Construction of 1 No. new two storey house (resubmission following A/31/19/PL). This application is a Departure from the Development Plan & affects a Public Right of Way.

Land between Ashurst and Badgers Ham Manor Way Angmering

Thank you for your internet representation made on 13th June 2019 which has been recorded as **'an objection'** with the comments as follows:

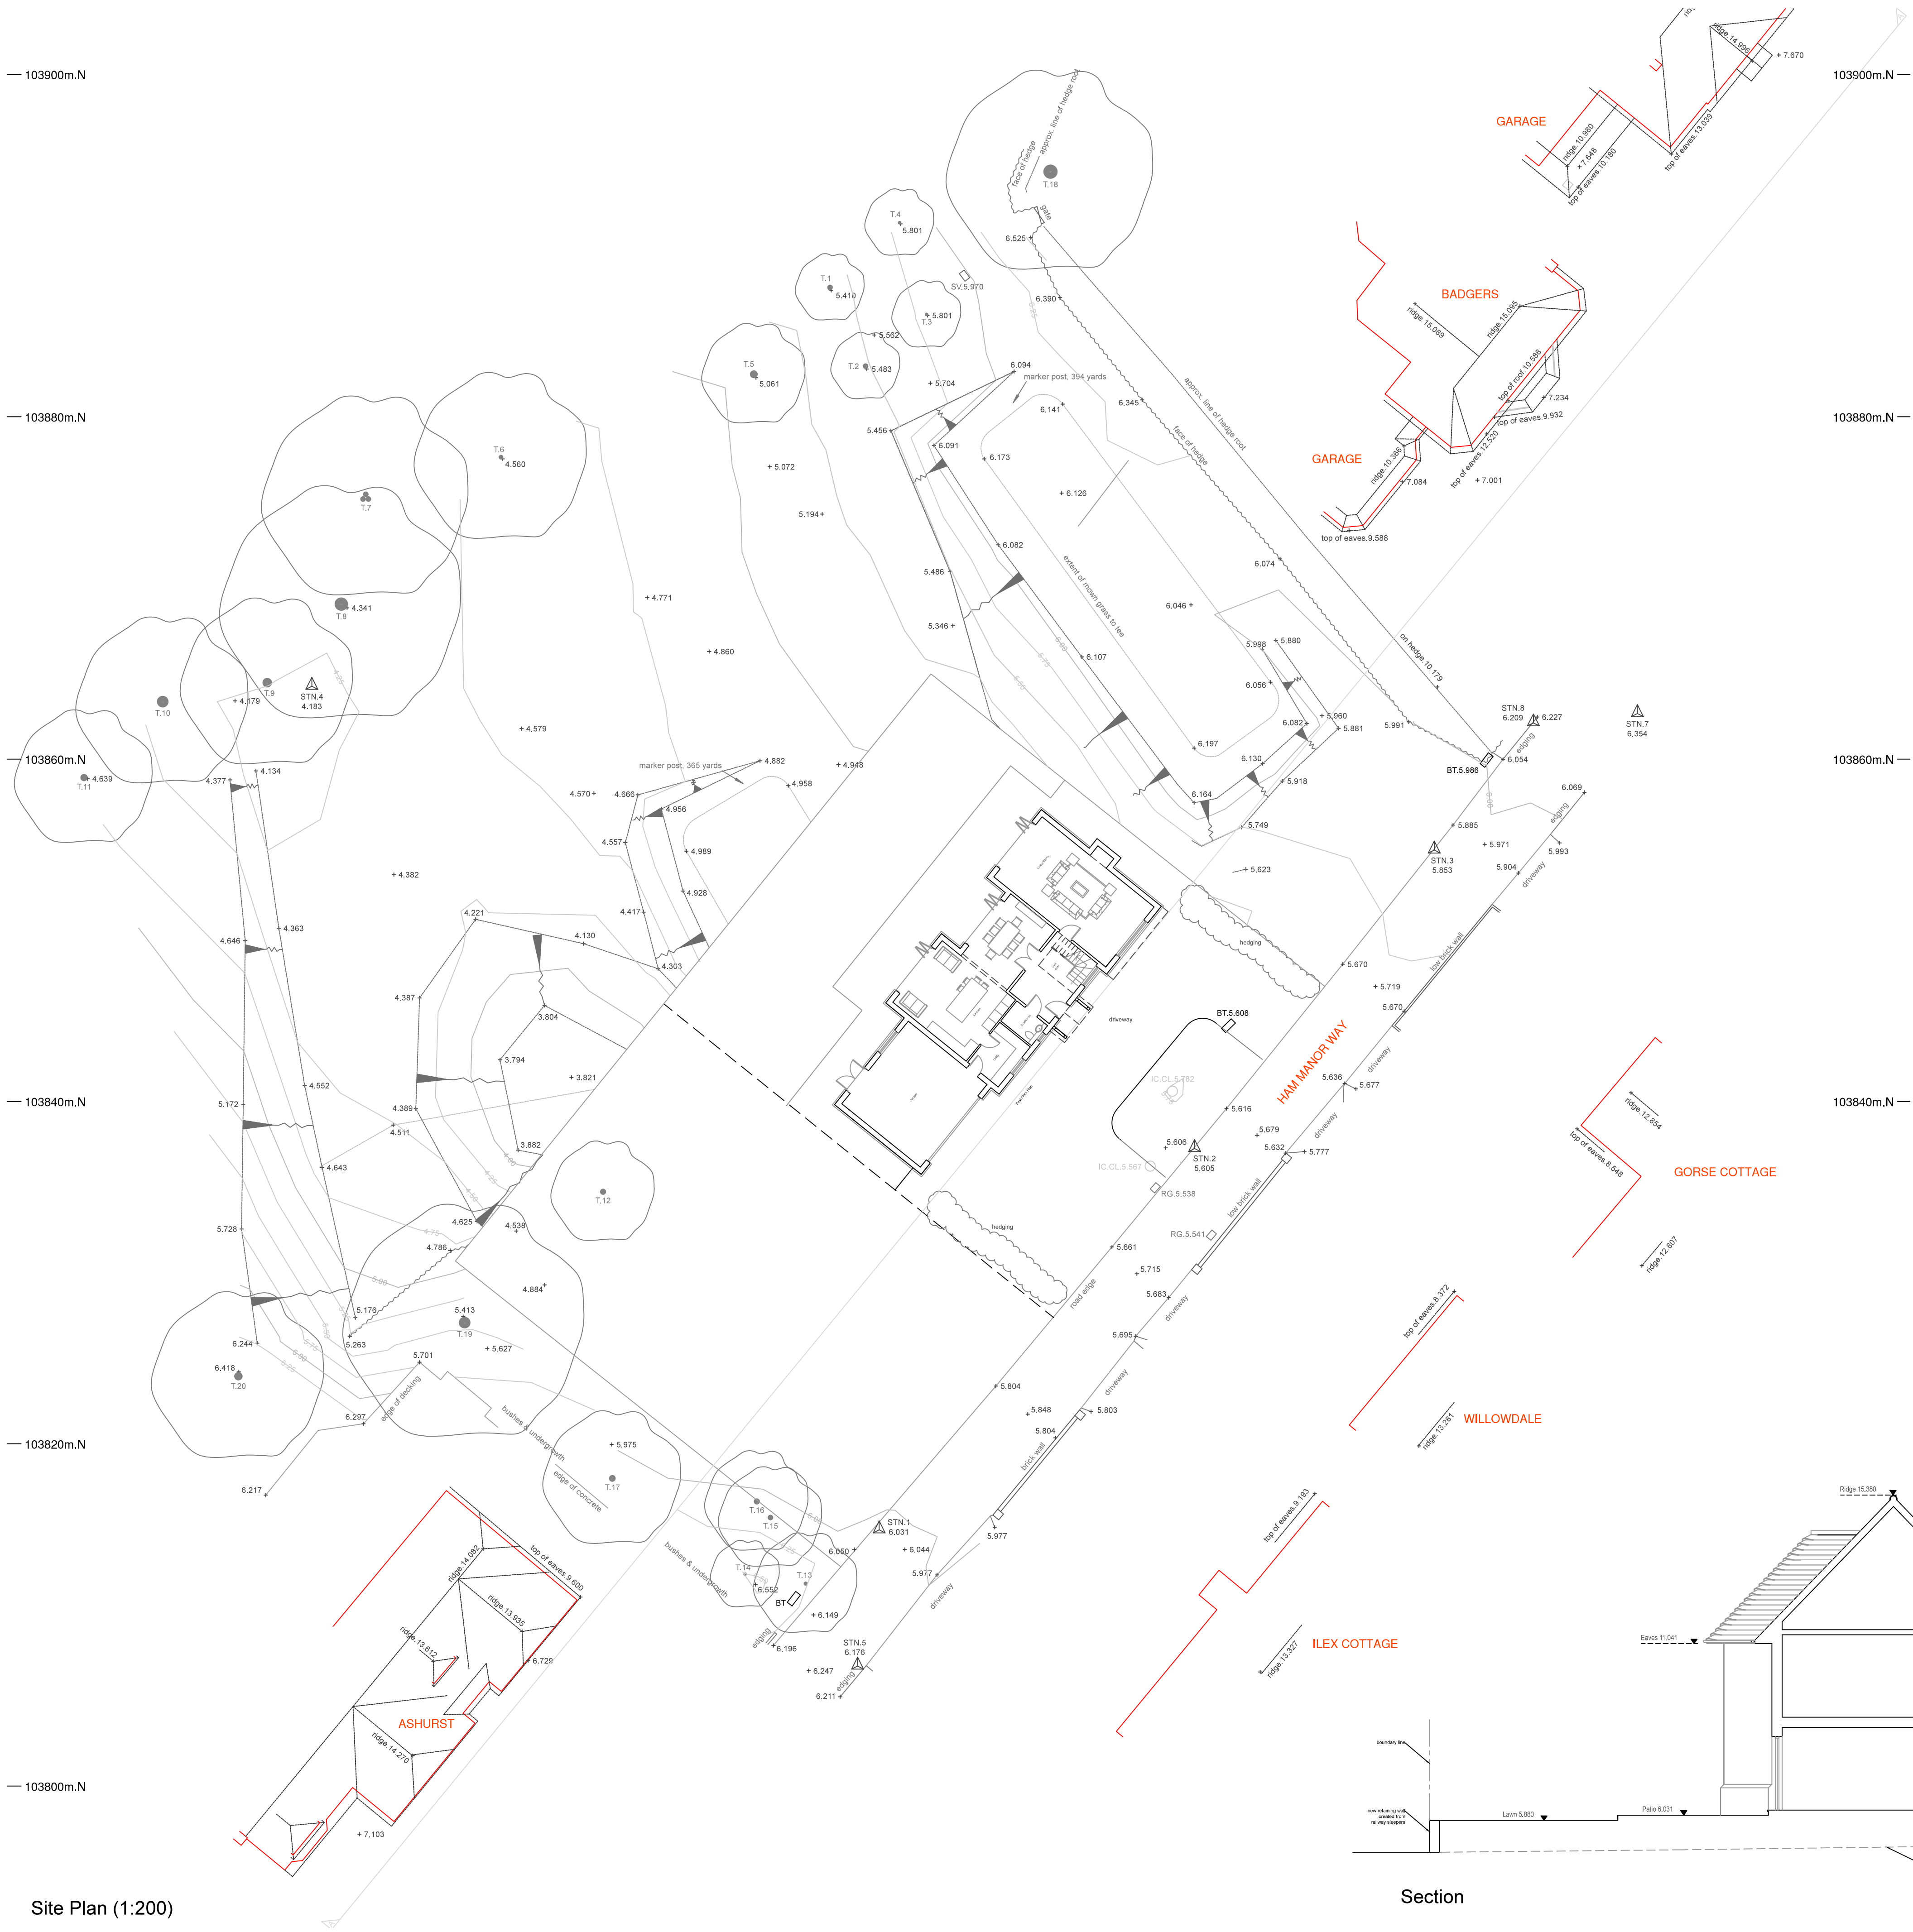
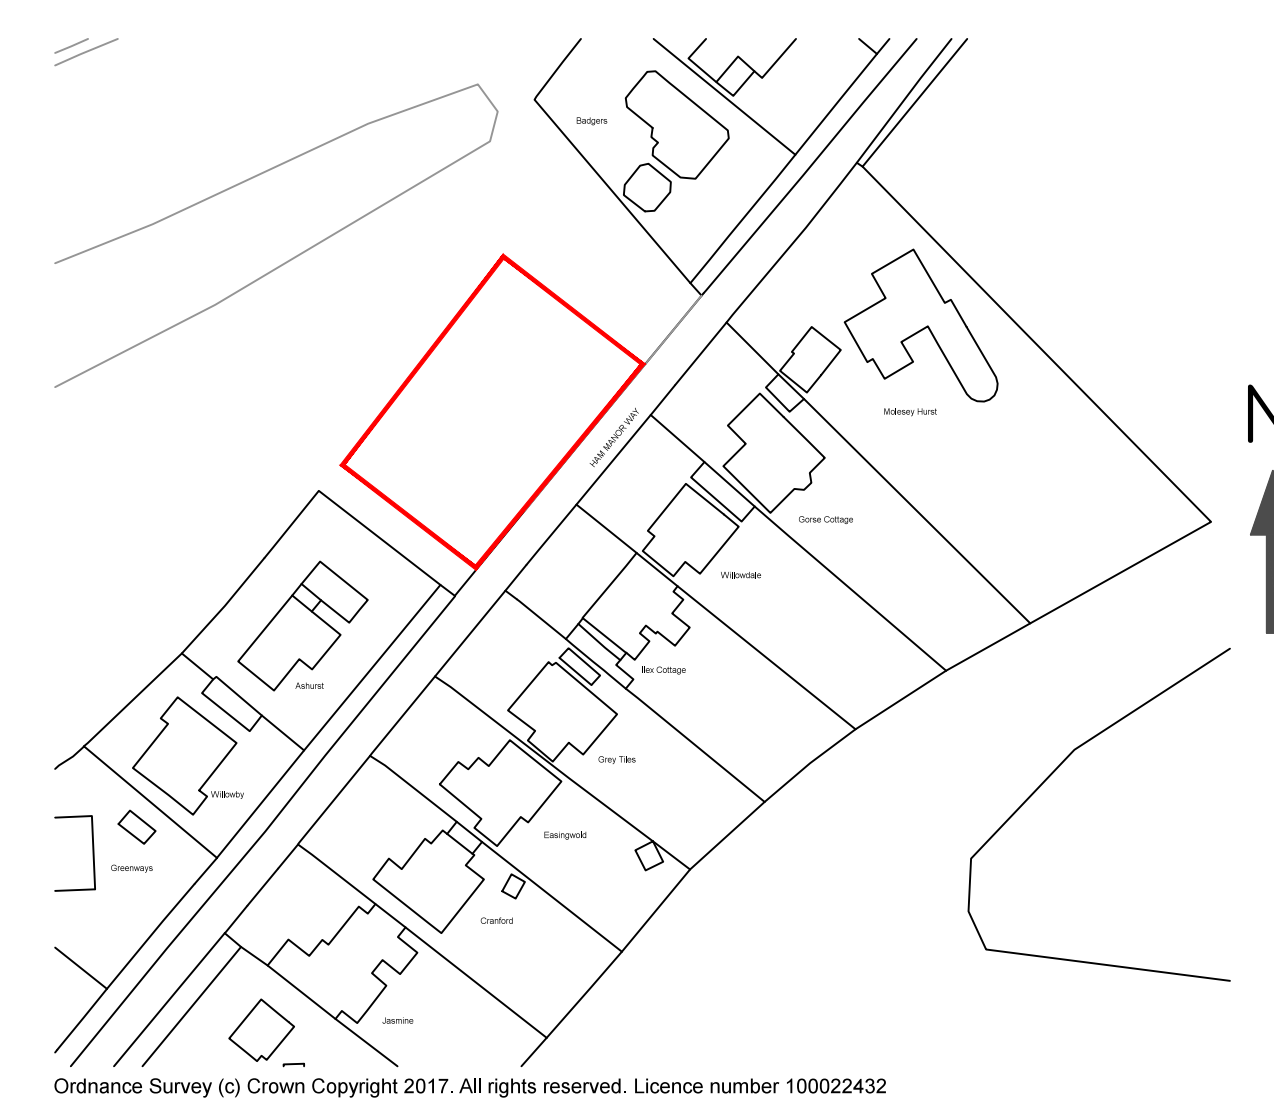
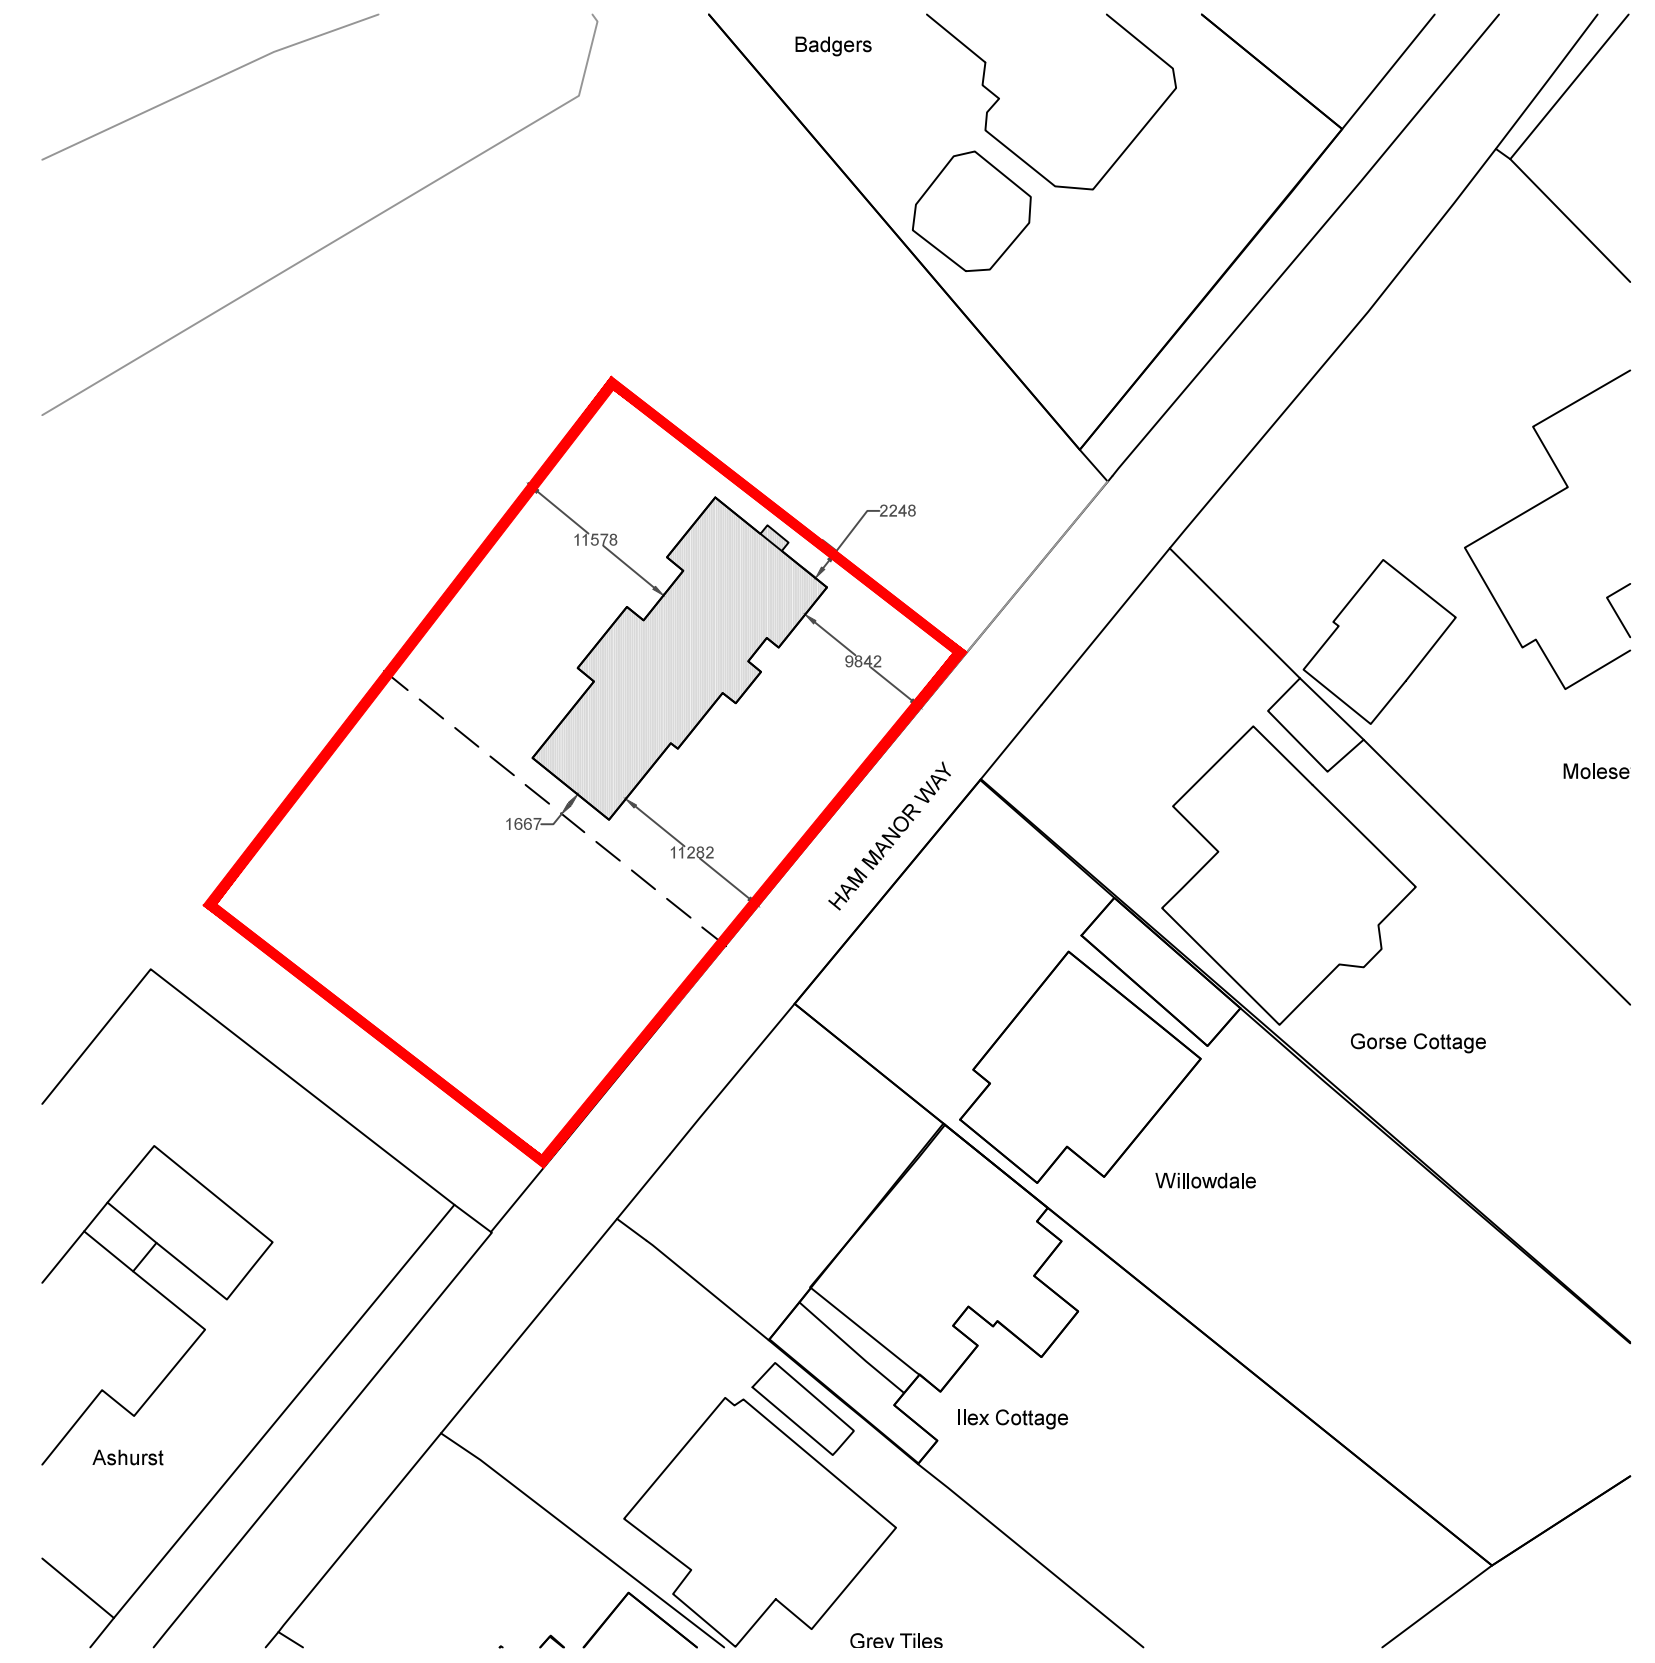
As shown on the submitted plan drawing, drawing number 1202.02.c, the proposed property is positioned a long way forward of the historical build line which can be seen from aerial photo's on Google map. On both sides of Ham Manor Way there is a defined line where properties are not built in front of. This again demonstrates the property is too big for the plot size whilst trying to gain a back garden.
